FW: P/42/26/NMA Land north of Sefter Road - SUB PLAN REQUEST

Subject: RE: P/42/26/NMA Land north of Sefter Road

You have included drawing 040269 Rev A.2 "GRP Trussed Apex Door Canopy" as a replacement to drawing 1308078 Rev A.3. However, the latter is not included in the plans list on condition 1 of P/49/21/RES. It is unclear therefore when or where that drawing was approved? Perhaps it was not originally a planning drawing (rather a construction drawing). Please advise.

GRP Trussed Apex Door Canopy

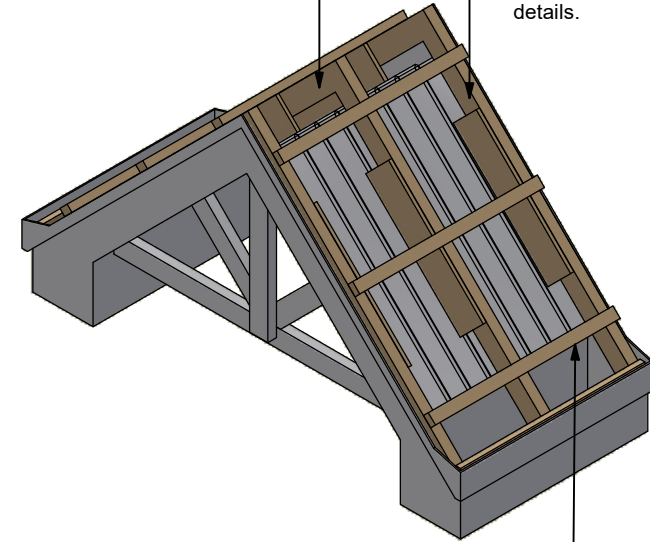
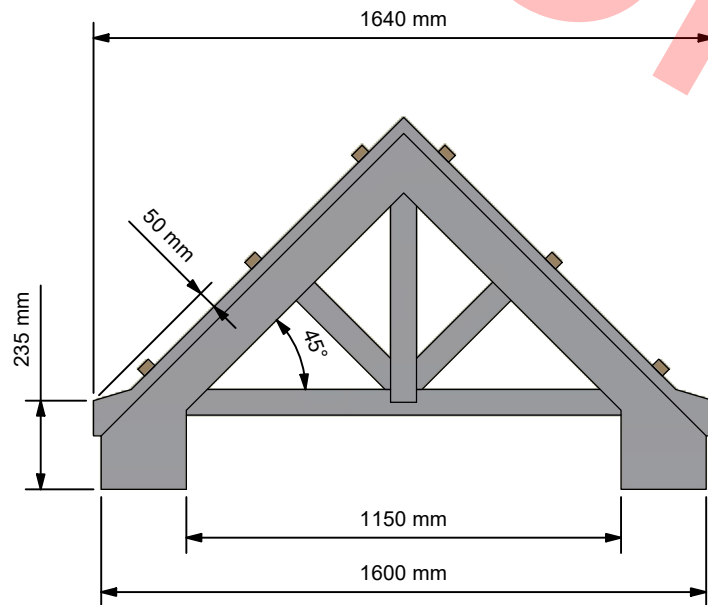
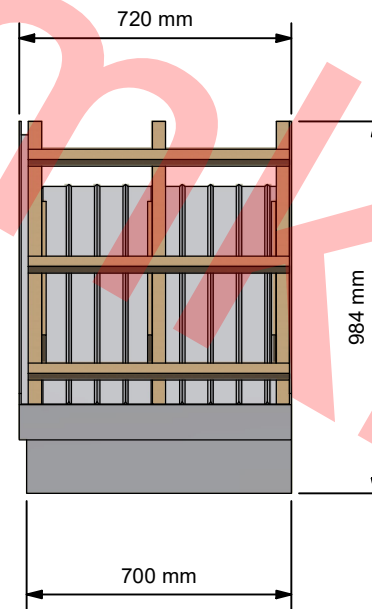
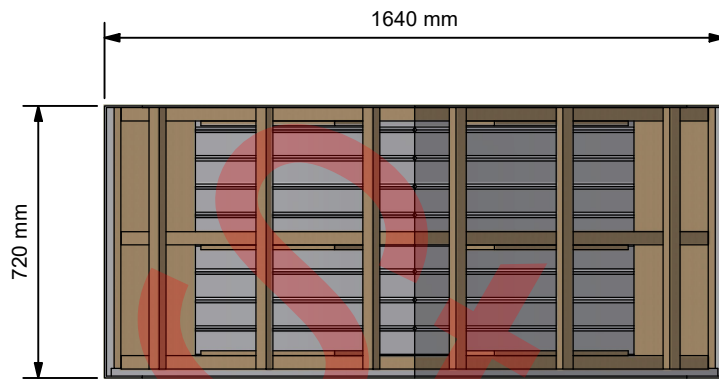
Can you also confirm (as it is not clear) what colour/type of tiles will be affixed to the new apex roof? Will they match with those on the main roof?

Apologies the drawing was to illustrate the canopy that was approved at RM. Please see attached the updated elevation drawing to supersede the approved version.
